# TR050007 Hinckley National Rail Freight Interchange

## Stoney Stanton Action Group

Comments on additional information supplied by TSH (10<sup>th</sup> Dec 2024) in response to the SoS's letter (10<sup>th</sup> Sep 2024)

5/2/2025

Appendix A Part 3 - Vehicle Tracking Sheet 2

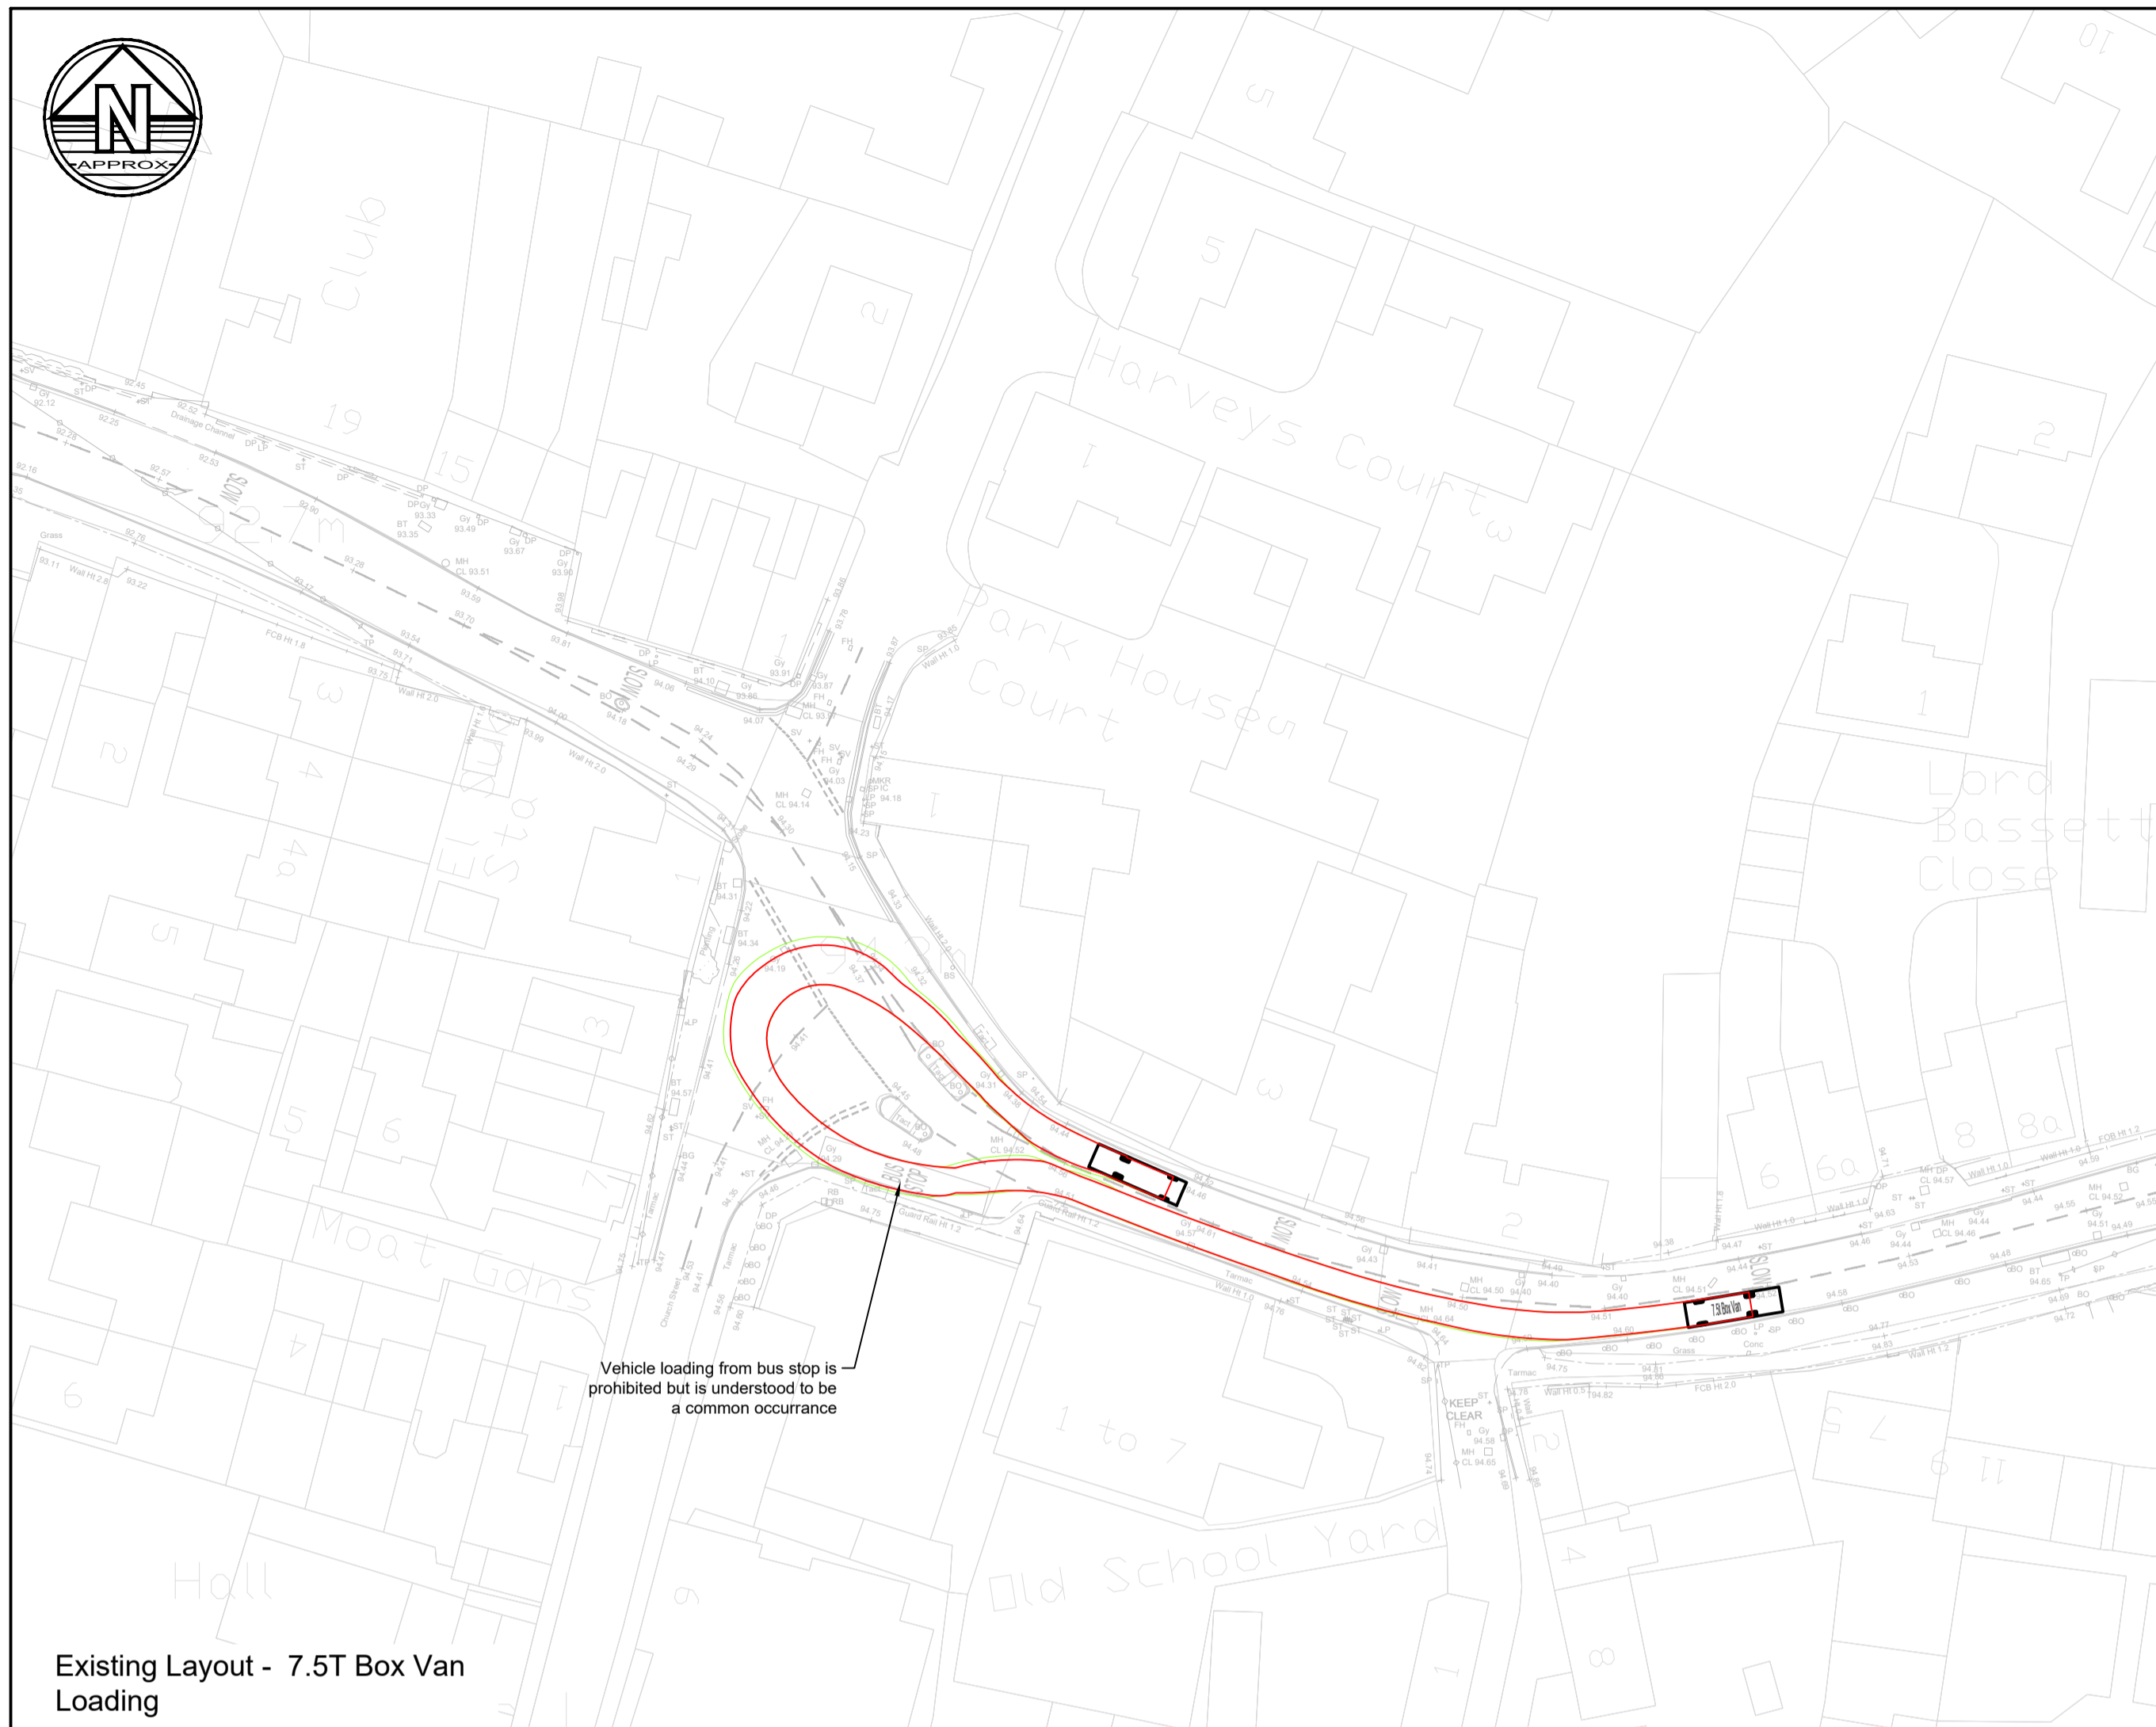
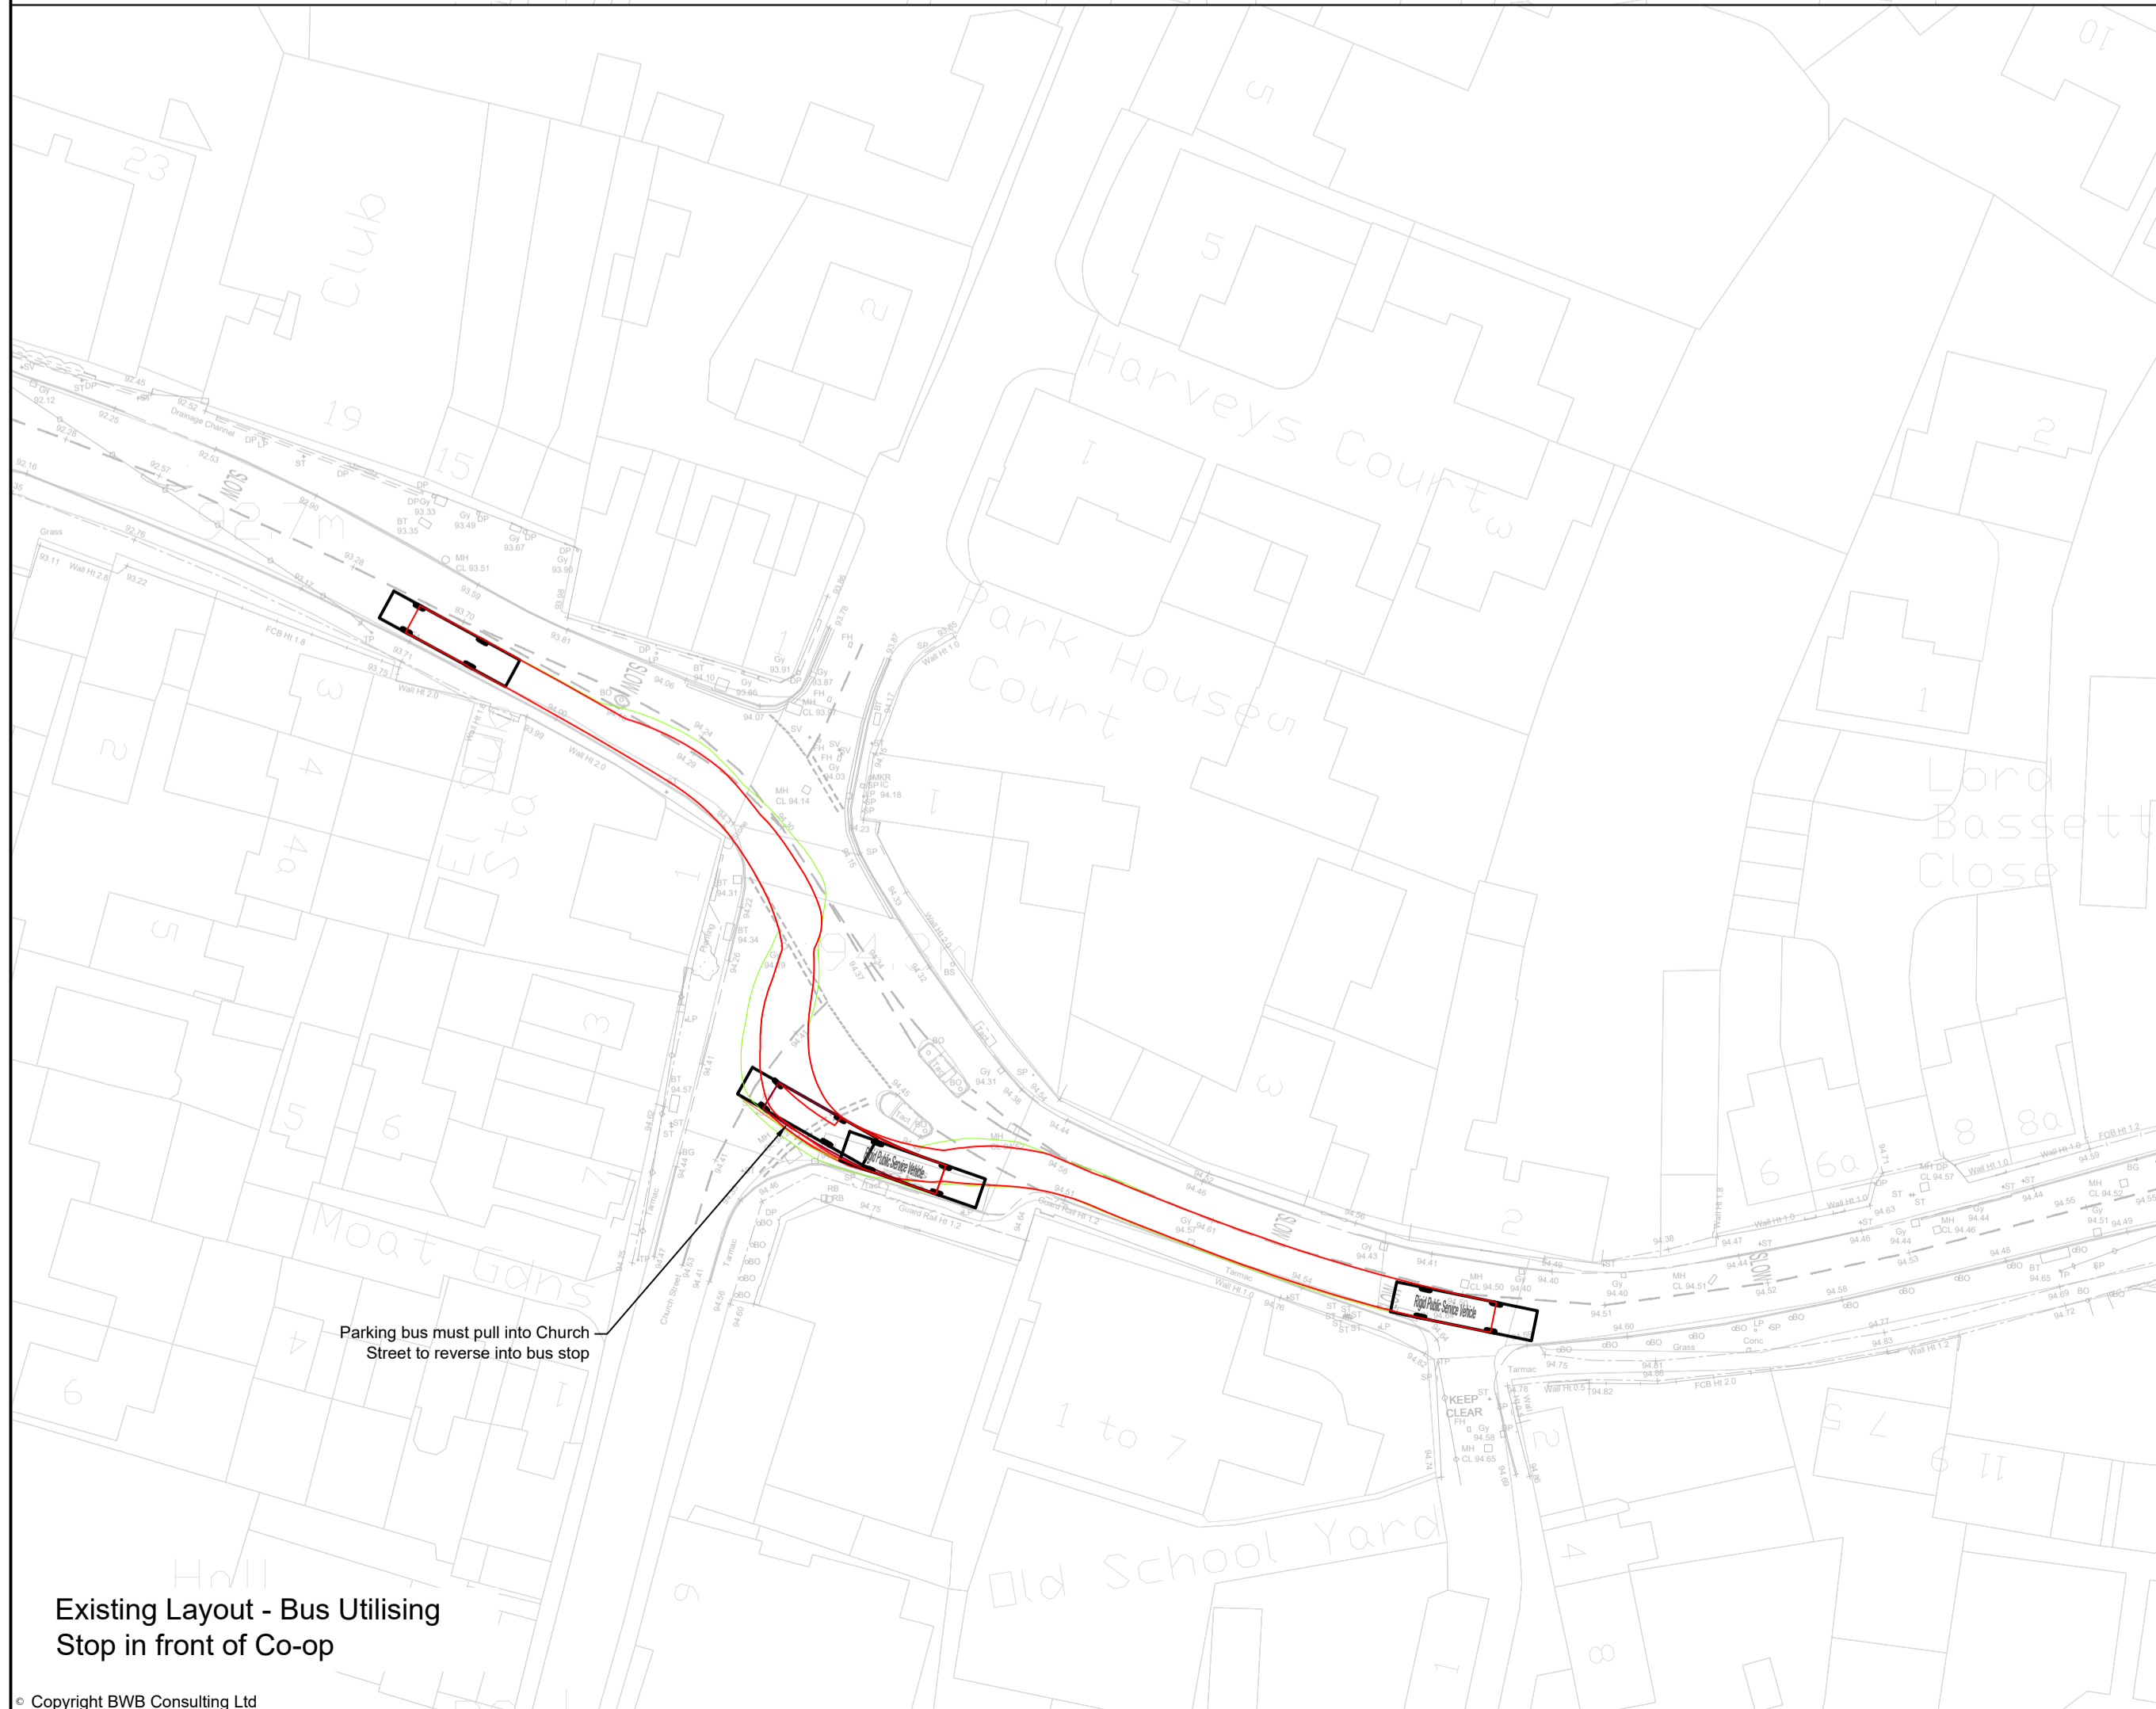
From a cursory read through "Appendix 2 - Sapcote Technical Note", another document that is overly dismissive of valid concerns. Table 2.1 in Section 2.12 of that document shows vehicle numbers for the B4669 to the West of the Co-op (Link 41) and to the East of the Co-op (Link 43). The HGV Annual Average Daily Traffic figures are inconsistent, for instance 2026 (scenario ii) Westbound is shown as 170 for Link 41 and 93 for Link 43. The difference is explained in section 2.13 by stating this shows that there is a significant proportion of local HGV traffic. From local knowledge it is easy to deduce that this is not likely, as all possible other destinations (e.g. Church Street and Stanton Road) are difficult to access by HGV. Additionally Westbound traffic for the Western Link (Link 41) increases by 10 in 2026 "with development", whereas the Westbound Traffic for Eastern Link (Link 43) increases by 1 in 2026 "with development". Either the HNRFI is creating additional local HGV traffic or the table is wrong. See photos in this document Section 4.
